Memorandum

To: Dave Merrill
From: Mike Nugent/Inspections Division Director
Date: 3/1/2005
Re: 133 Anderson St.

I have commenced the review of the remainder of the building plans and require the following information or have the following questions:

2 SECOND FLOOR FRAMING PLAN
S1-1 3/16" = 1'-0"

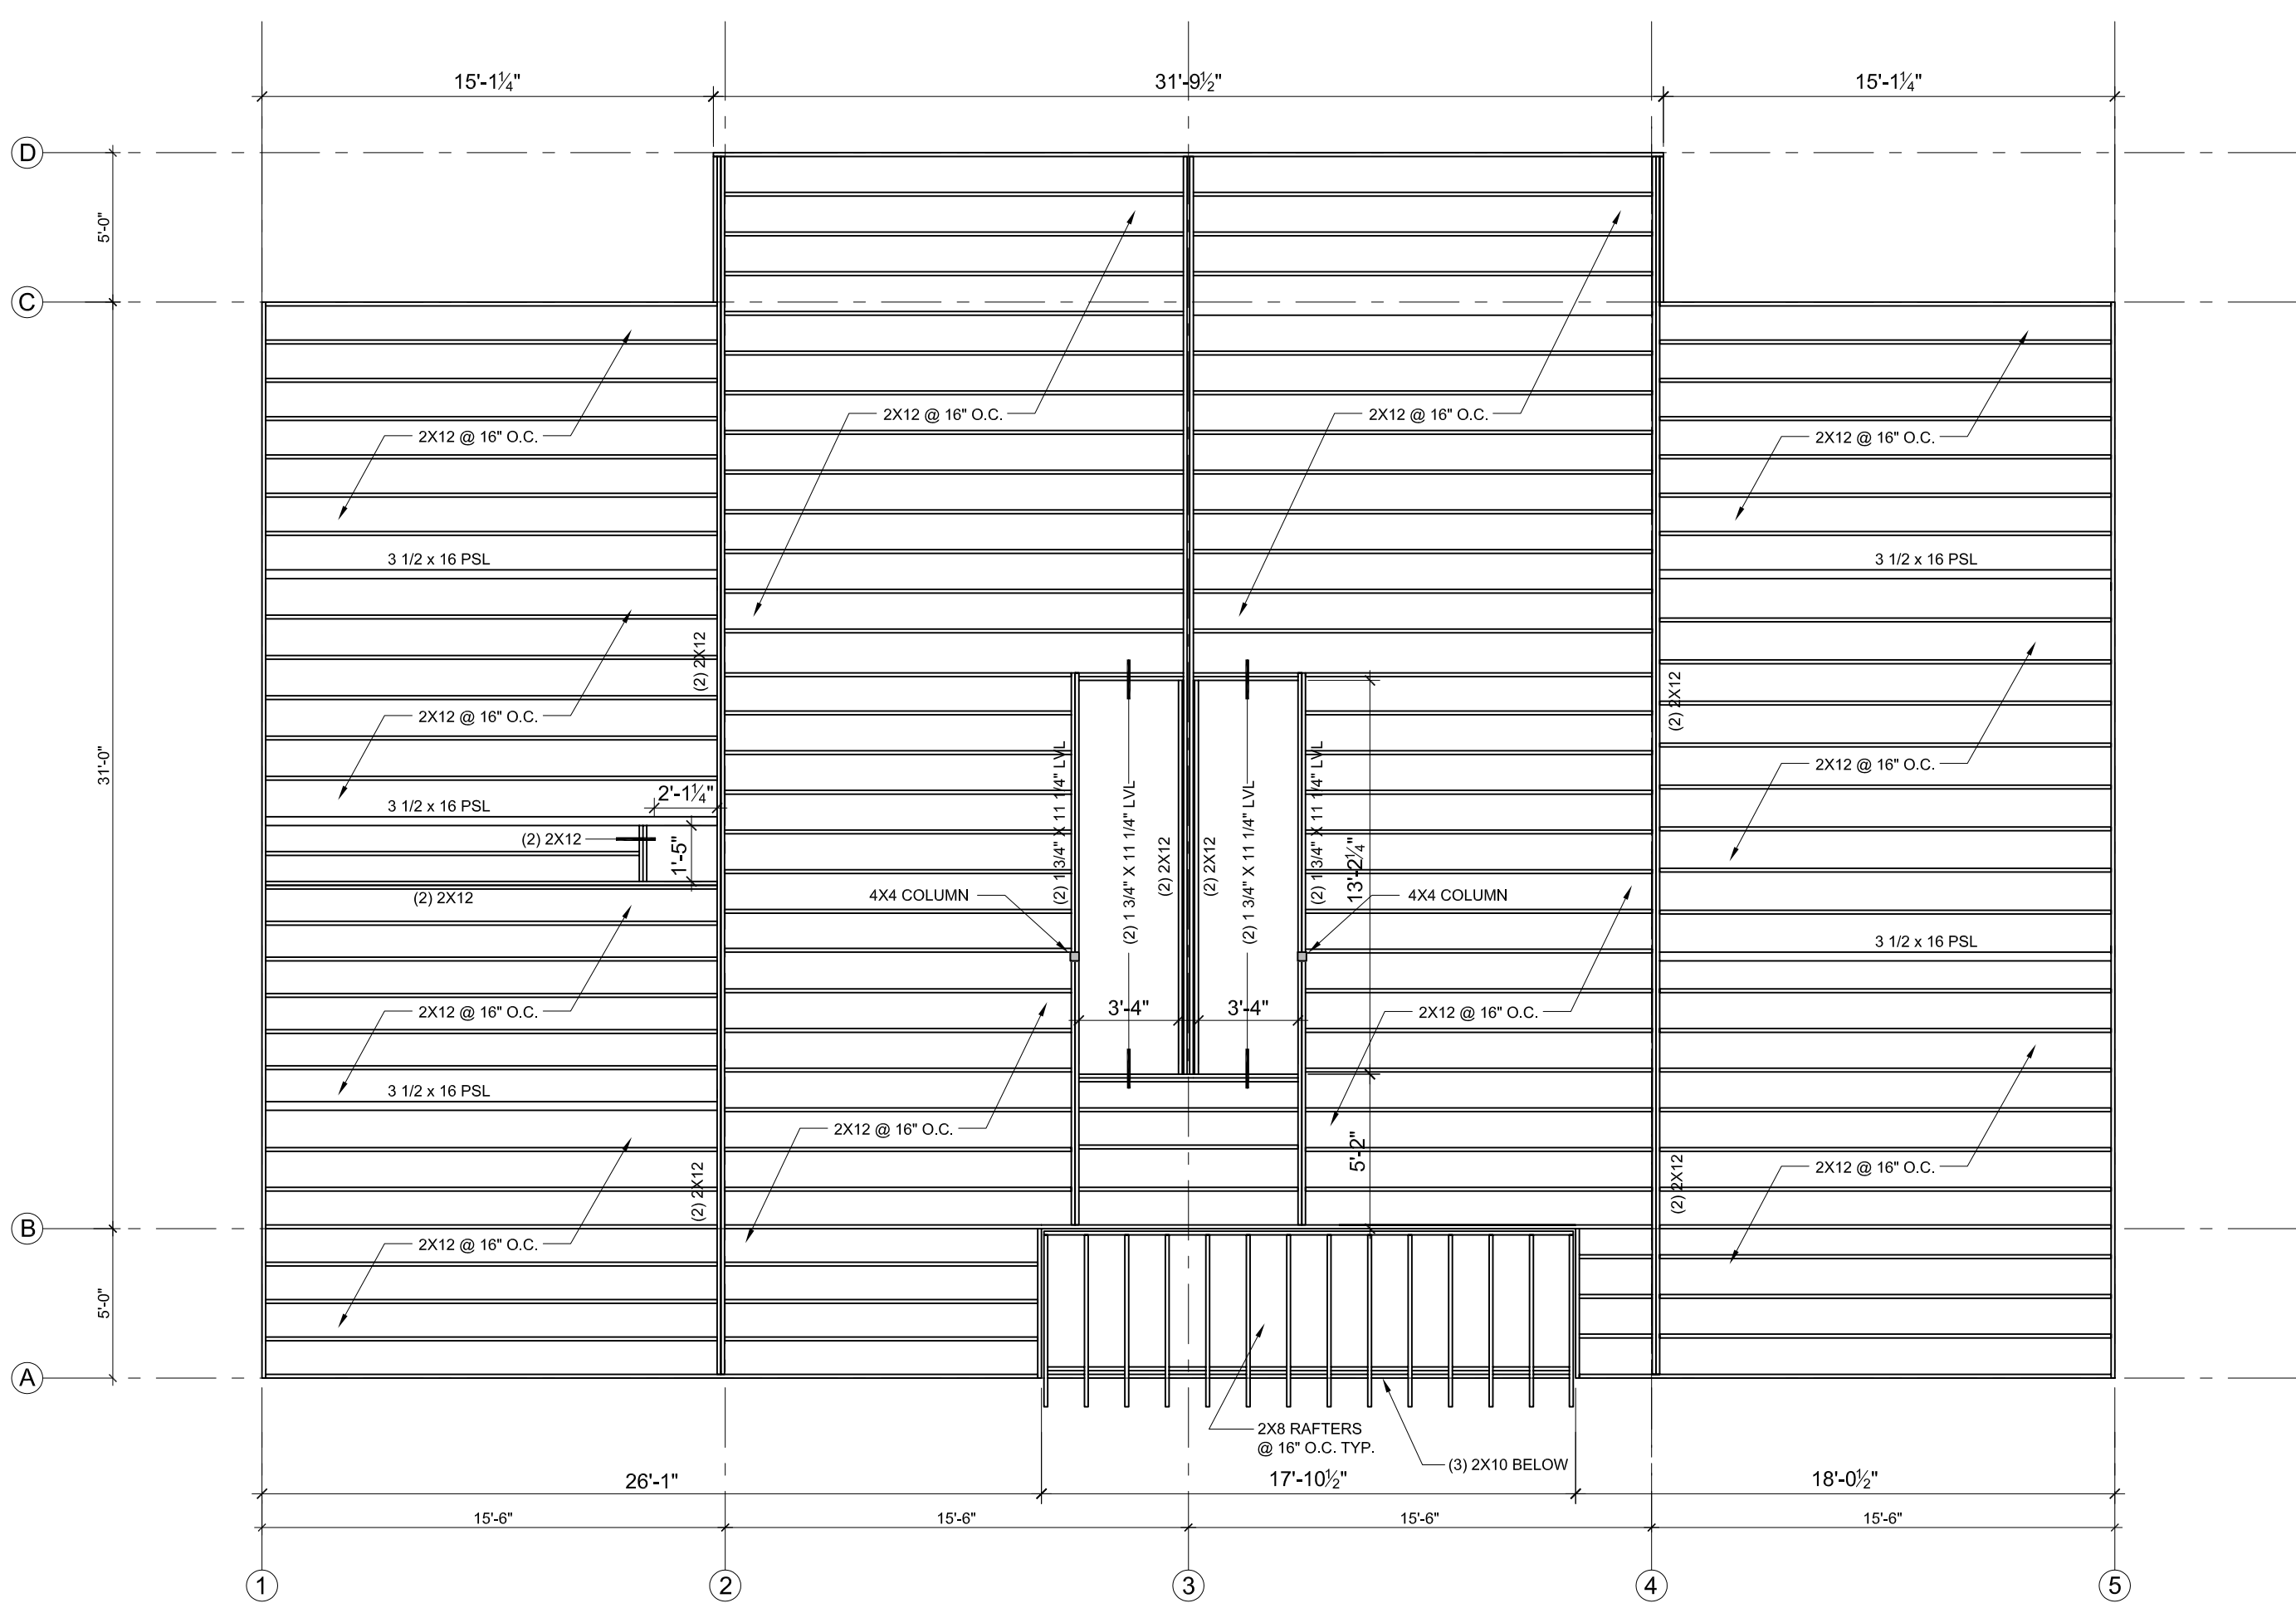
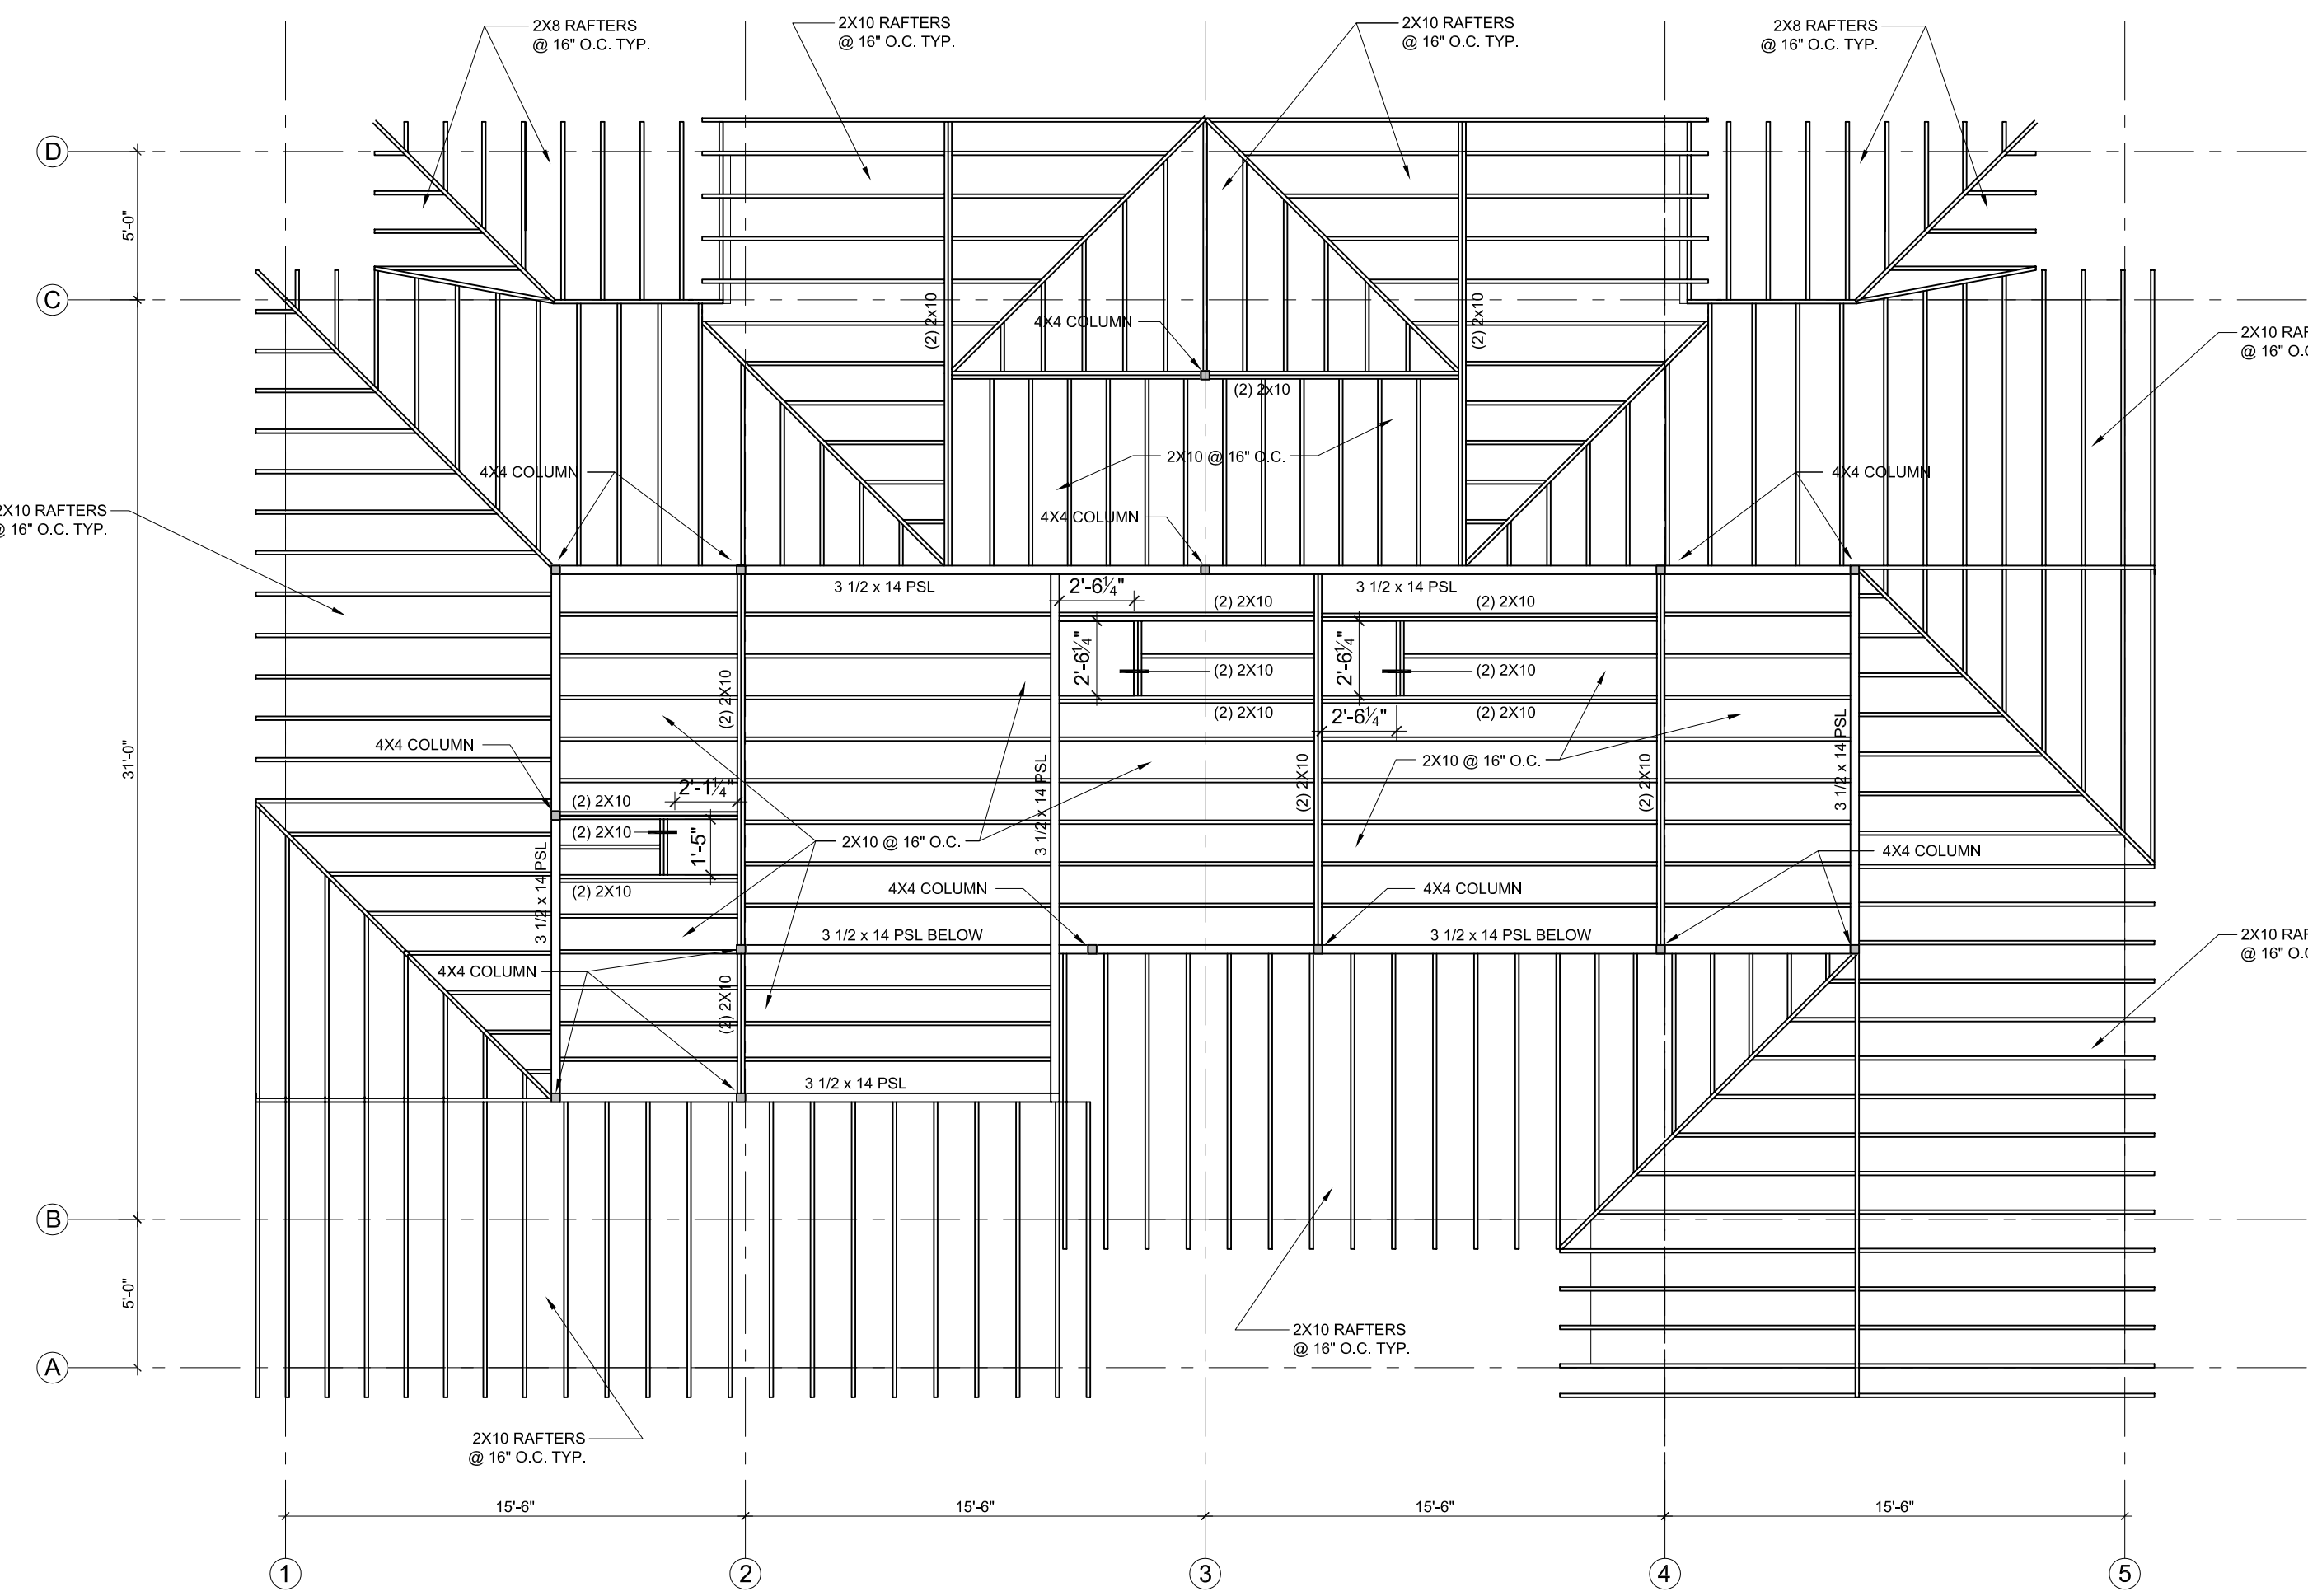
- 9) Details 6, 8 and 9 on S1.1 do not match either rated floor assembly 1E or 1F
- 10) The electrical notes do not specify battery backup in the smoke detectors.
